Re: 64 Melthorne Drive 6112/APP/2021/917

Ms Mandeep Chaggar
Planning Officer (part time)
Planning Environment and Community Services
London Borough of Hillingdon
(E-Mail) mchaggar@hillington.gov.uk

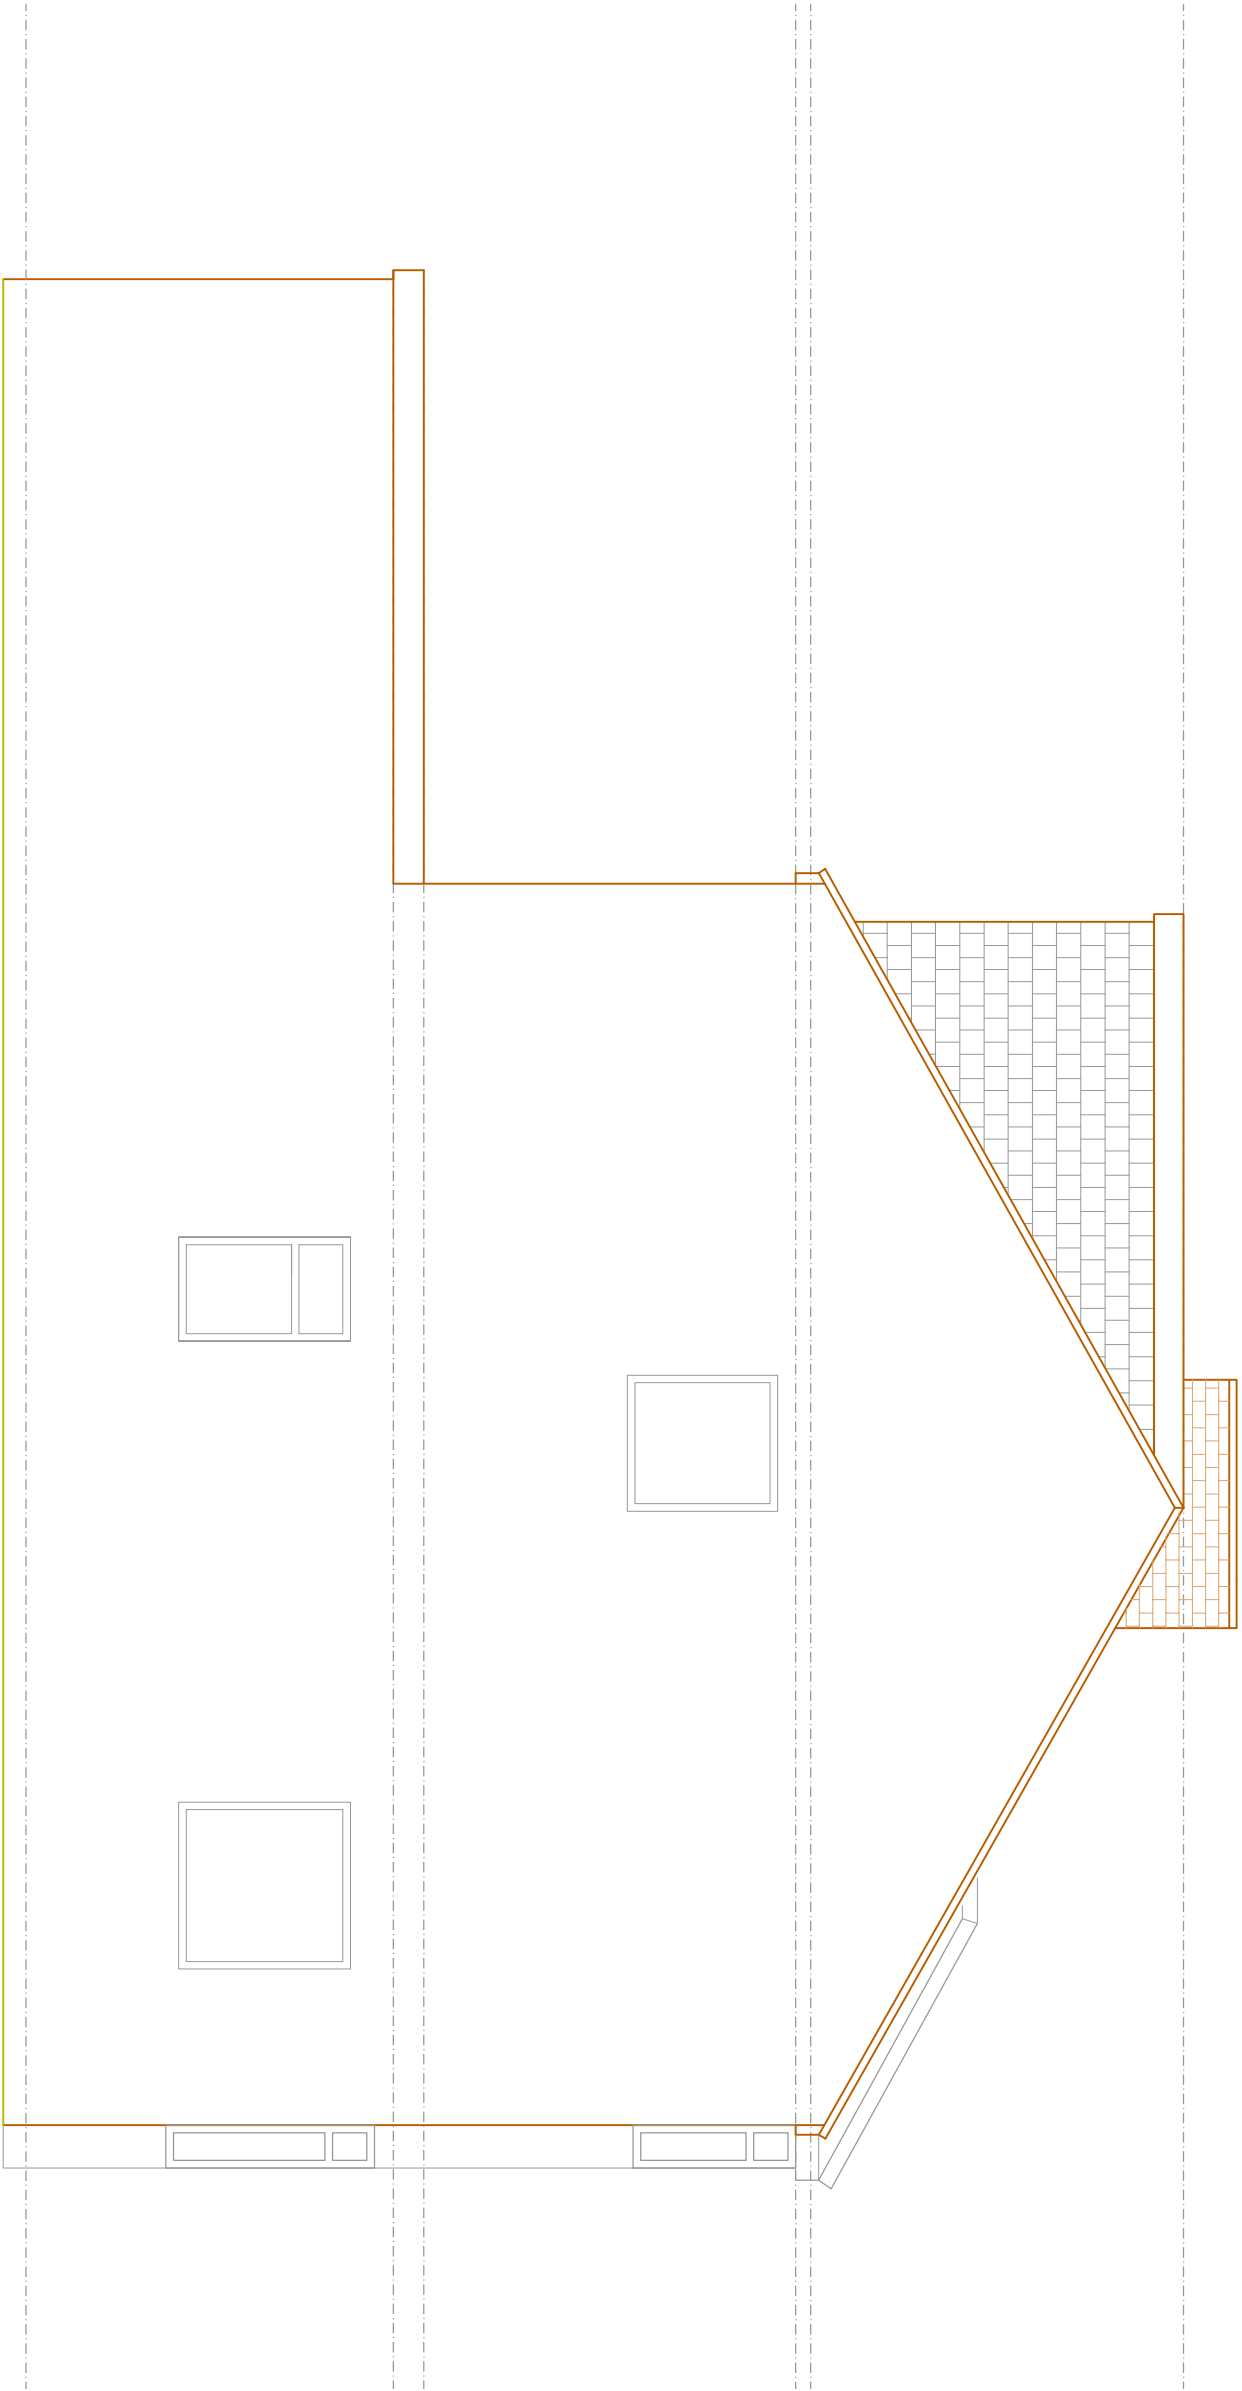
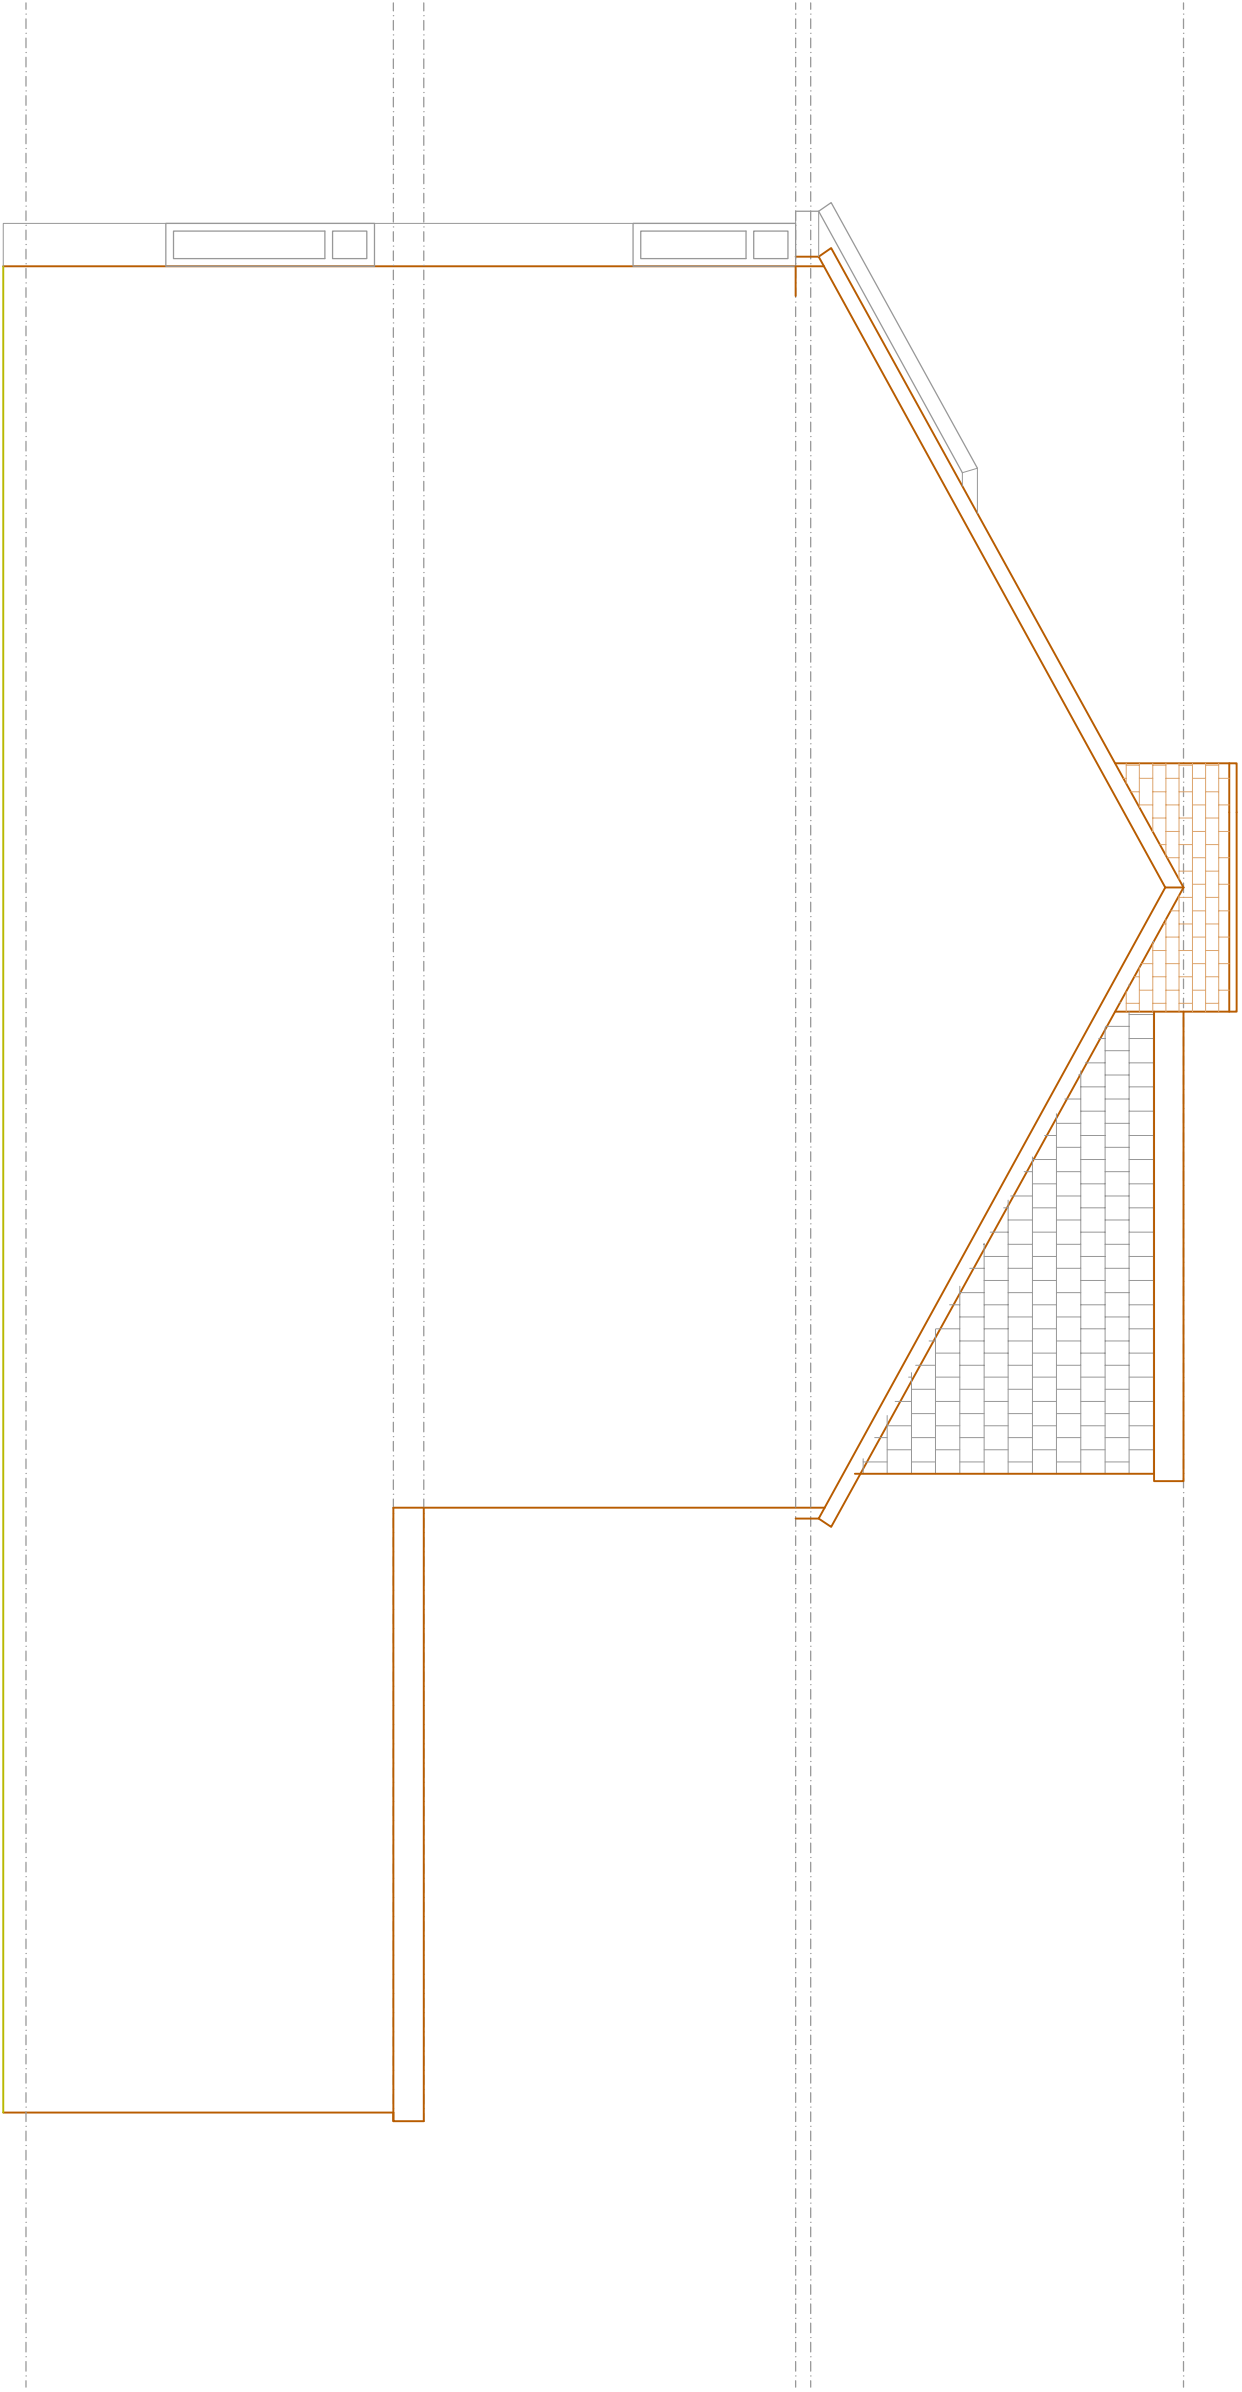
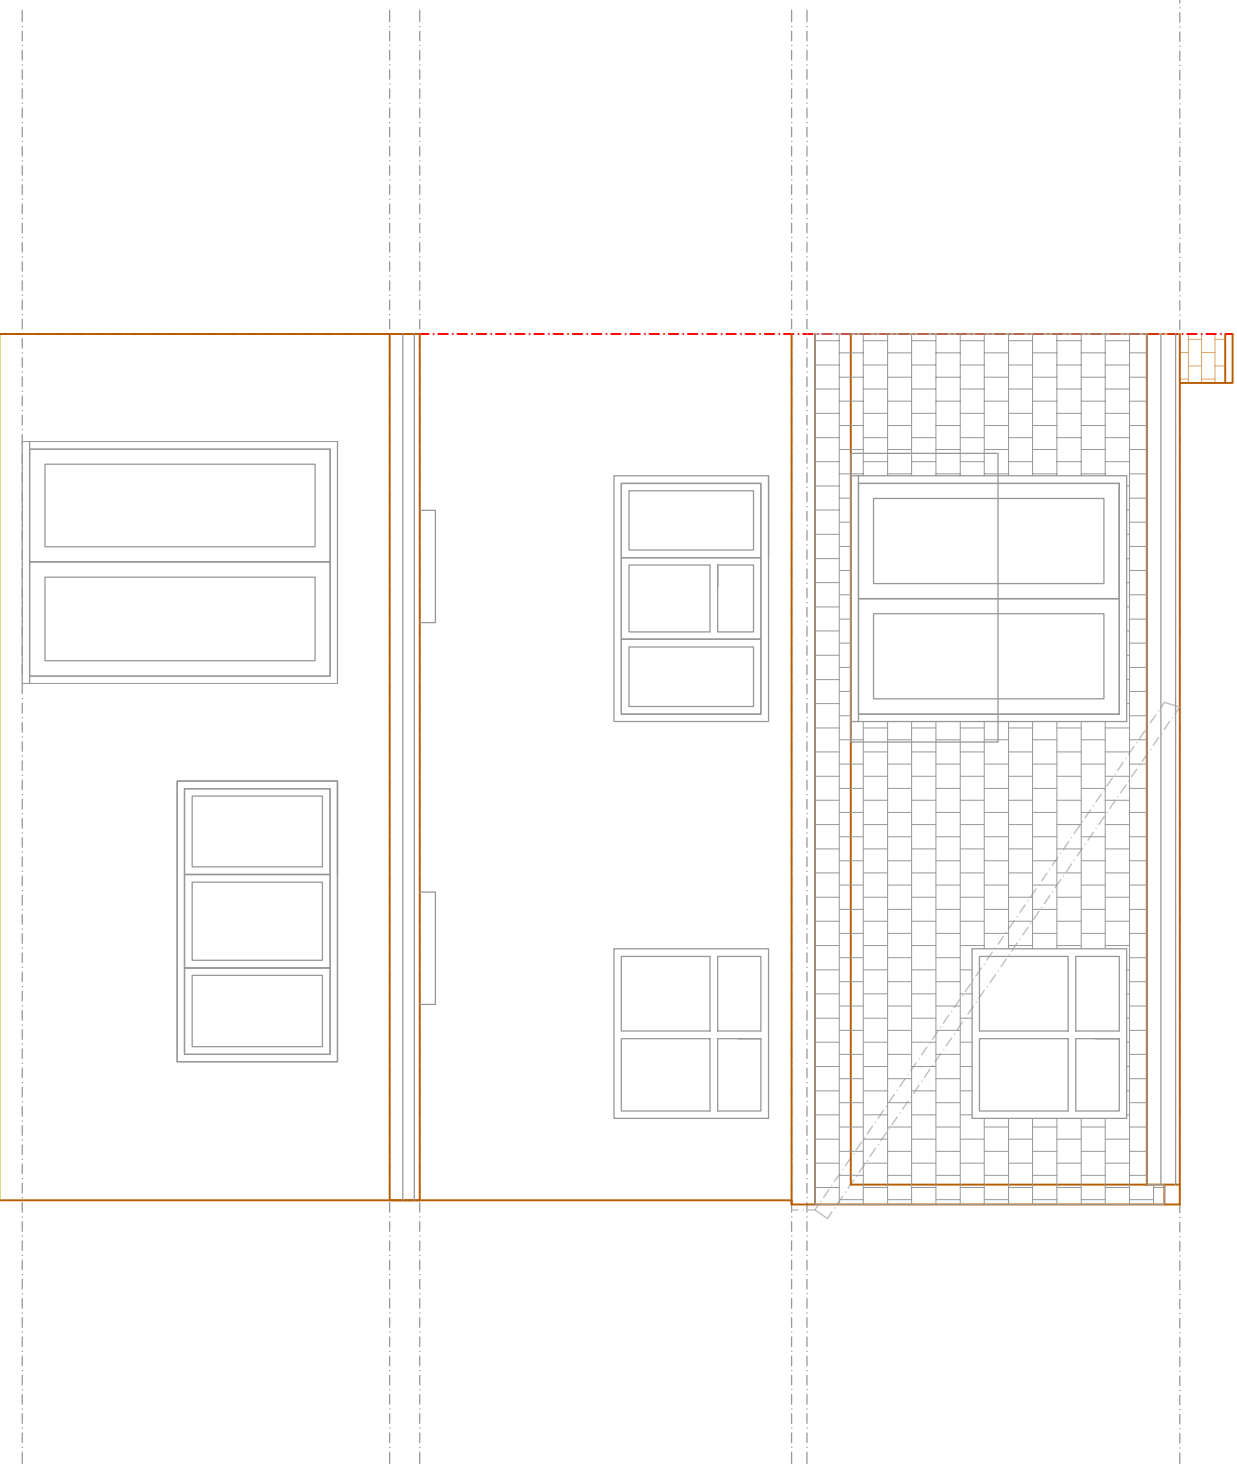
Further to my email below requesting site photos, please can you confirm the rooflights will not protrude more than 150 mm above the roof plane and lower than the highest part of the original roof.

Materials will match the existing dwelling;
The rooflights are less than 150 mm above the roof plane and lower than the highest part of the original roof.

I can confirm the roof lights will not protrude more than 150 mm above the roof plane and lower than the highest part of the original roof. I can also confirm materials will match existing.
